From: Jean Fraser
To: Mary Westort Casale
Date: 2/16/2016 3:30 PM
Subject: Re: 31 Fore St. / comments

I just wanted to update you re the discussion at the PB workshop on this.

DRAWING NO. **L-1**

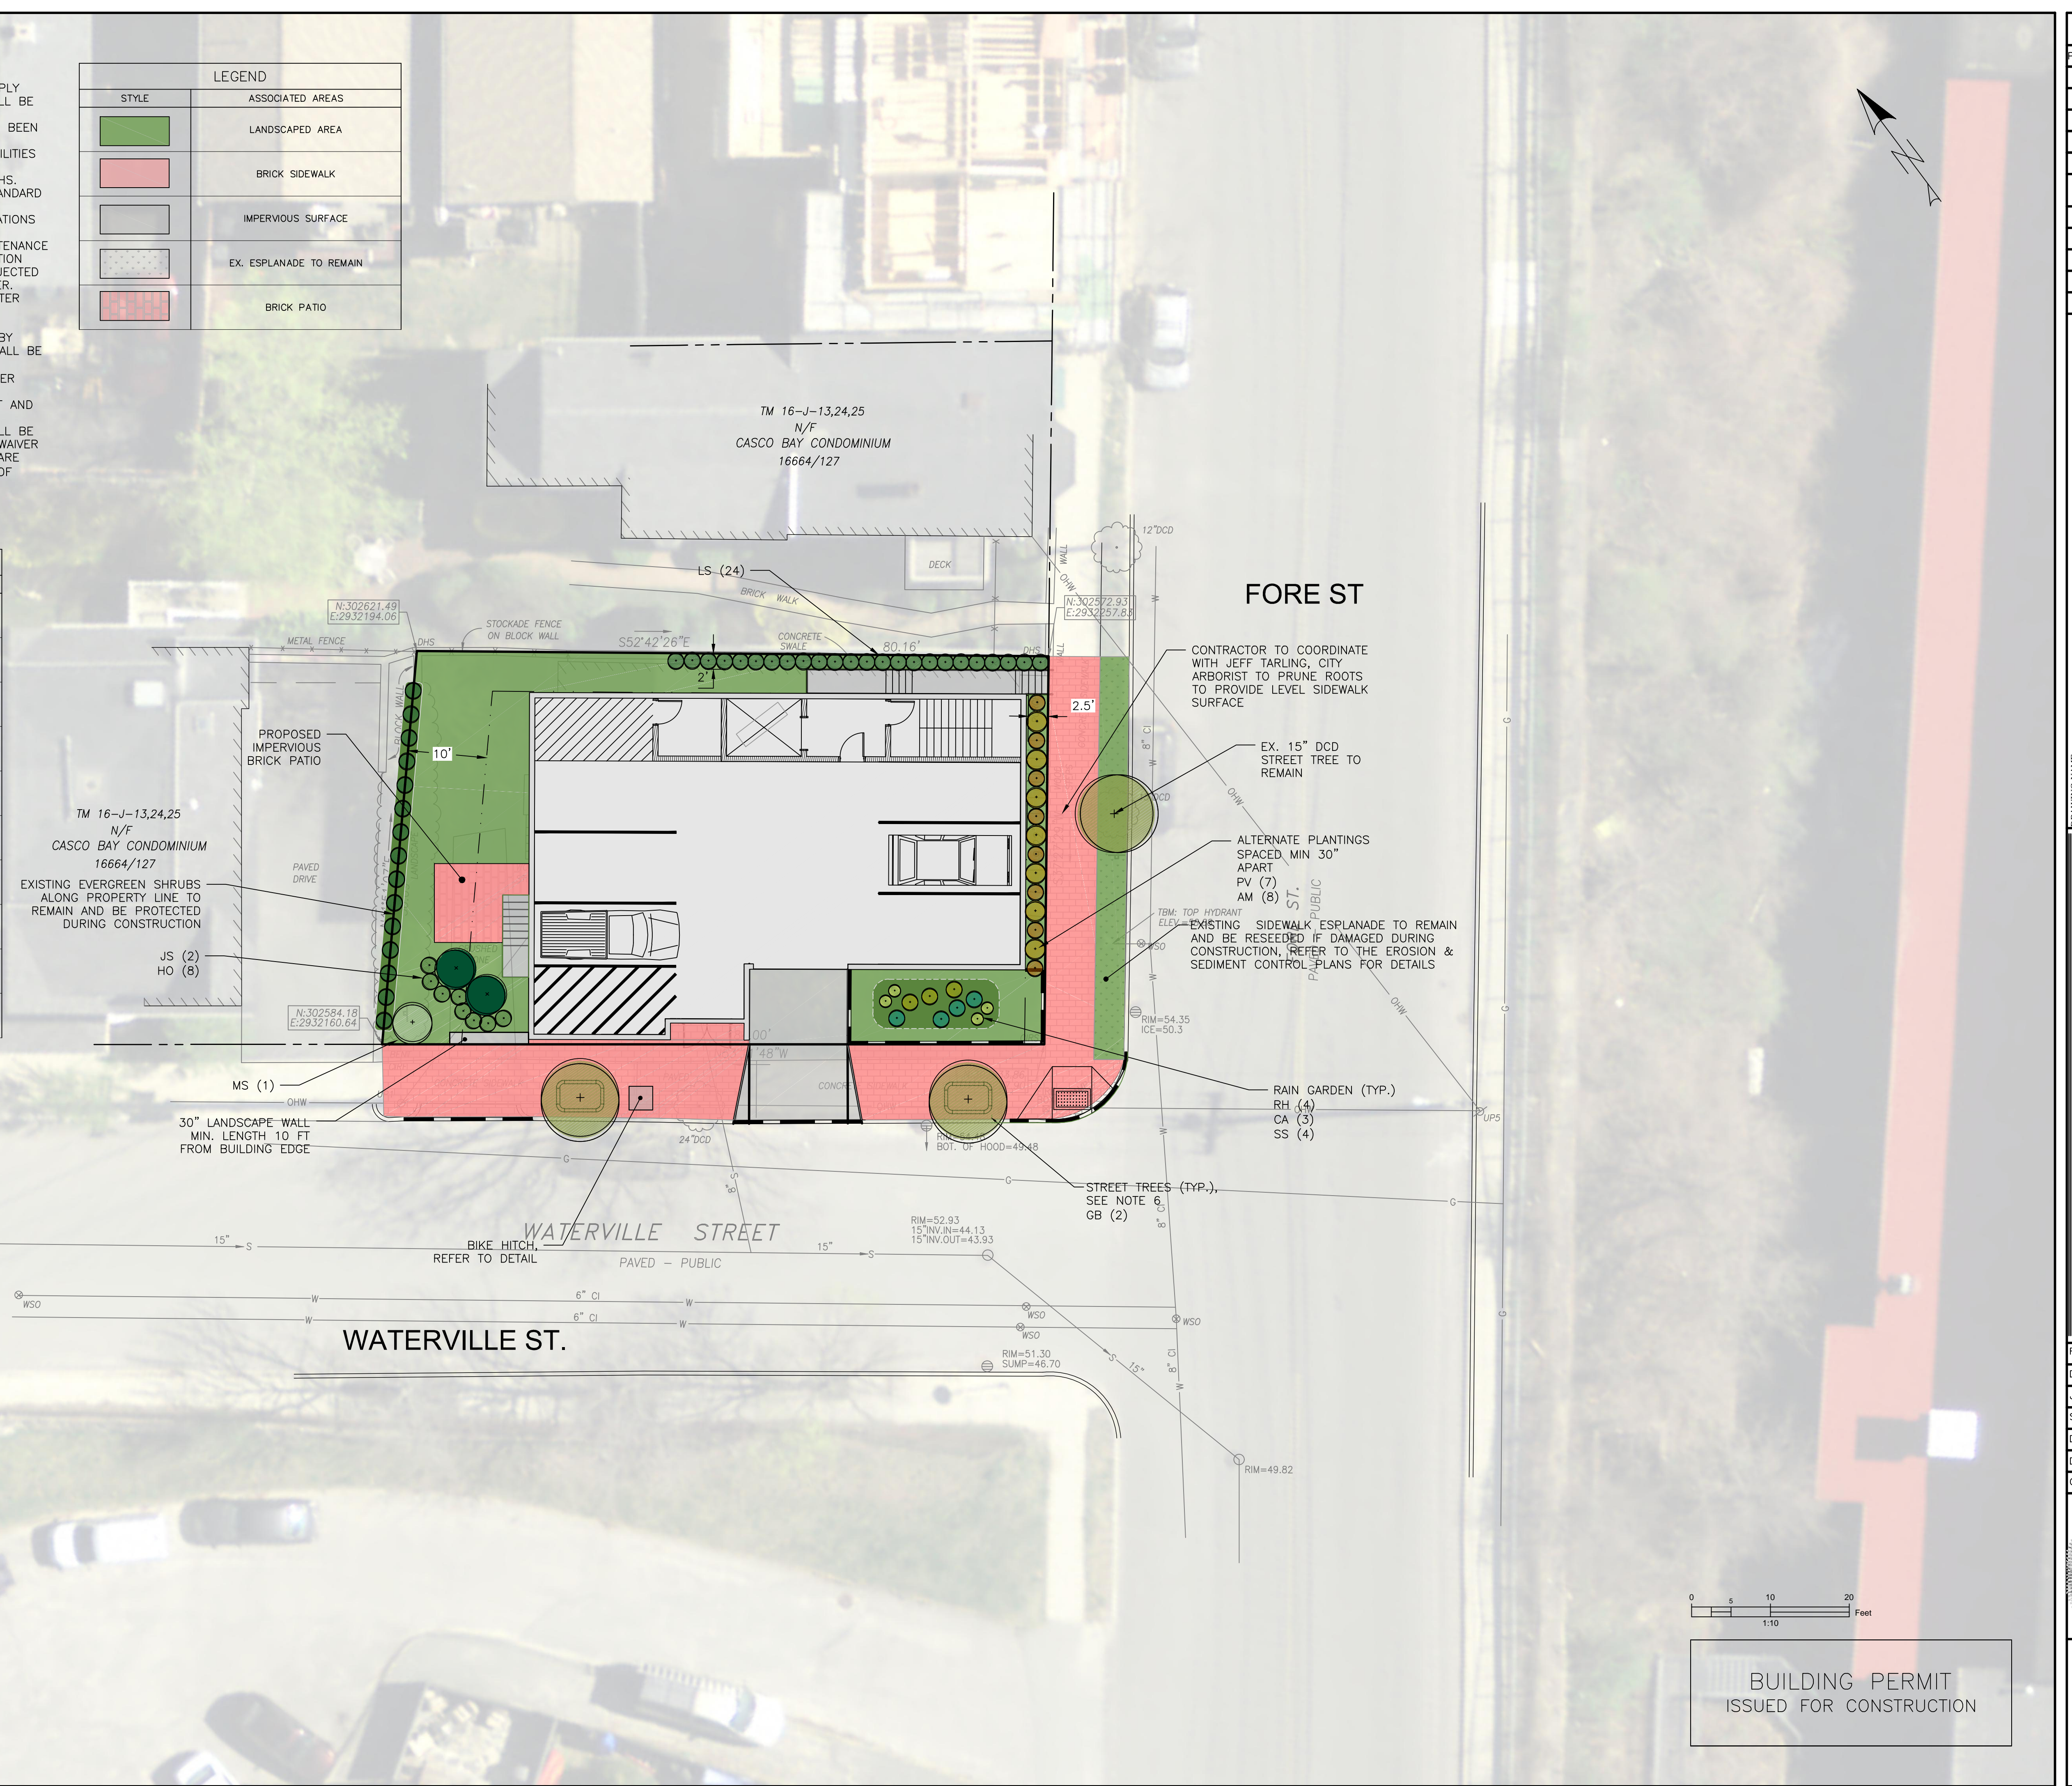
A couple of the PB members asked for more photos and info as to why this tree should be removed. The applicant will need to include this in the final submissions.

I just took this photo of the tree in question ,and clearly this tree is not an issue .It is established and has been like this for a number of years . If the city continues to take down trees to suit developers needs , I fear we will no longer be "the forest city " It appears as though it does interfere with the driveway plans . Also as the new R6 zoning barley leaves any open space on the lot for landscaping ,perhaps a tree or trees along Fore St at the front of the building would assist in meeting requirements

However, the City Arborist supports its removal and considers the two replacement trees acceptable.
